SITE DRAINAGE ON LAND AT THE END OF KEMPLE VIEW

Highway Development Control

Highways and Transport Lancashire

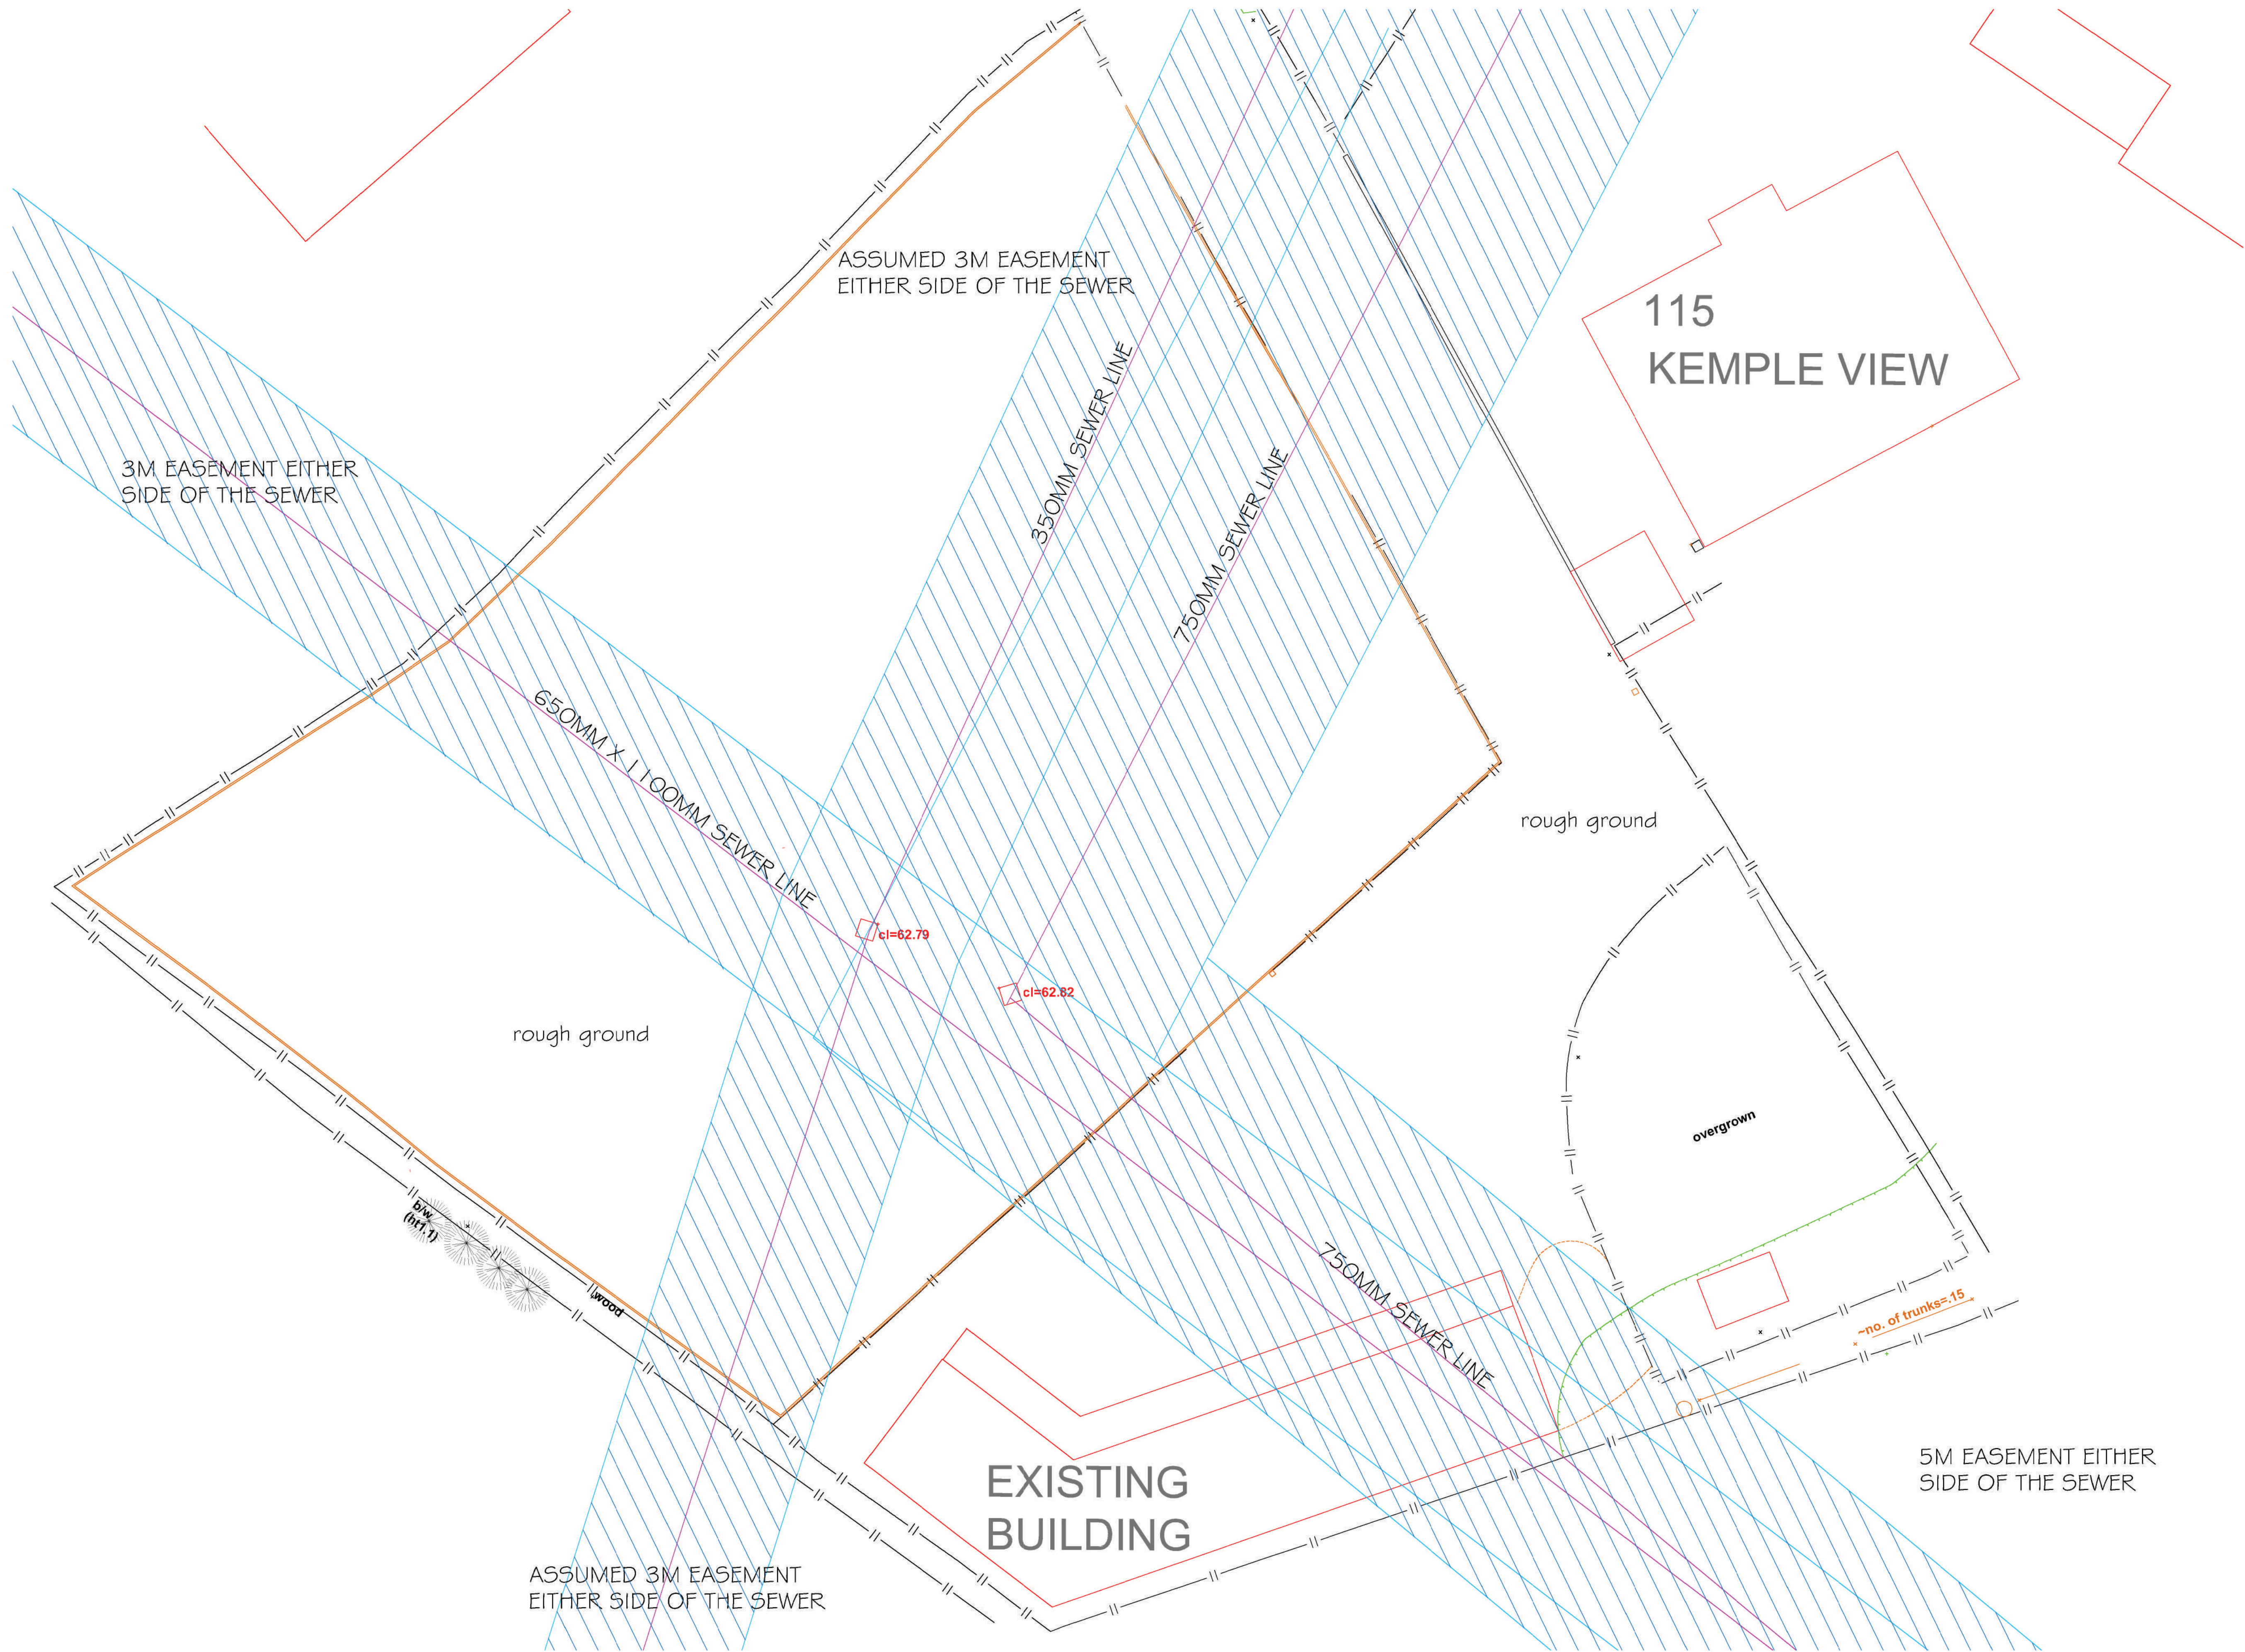
Further to our site meeting held on Monday 1 November 2021 I attach

a revised plan which demonstrates the potential to divert the highway drain around

house plot 2 as shown.

We have based the plan on the basis that there will be a connection point on the southern boundary following the installation of a concrete ring chamber on the adjoining land as discussed.

Our client will be installing a new compliant chamber on their land as shown and the drain line will have a 3m easement either side.

The excavations will need to be carried out in strict accordance with your requirements and we are aware that the diverted drain is close to an existing UU drain position.

Please can you advise how we carry out site excavations in close proximity to UU pipes.

Please proceed with you application we are satisfied with your proposal for the diversion of the drain.
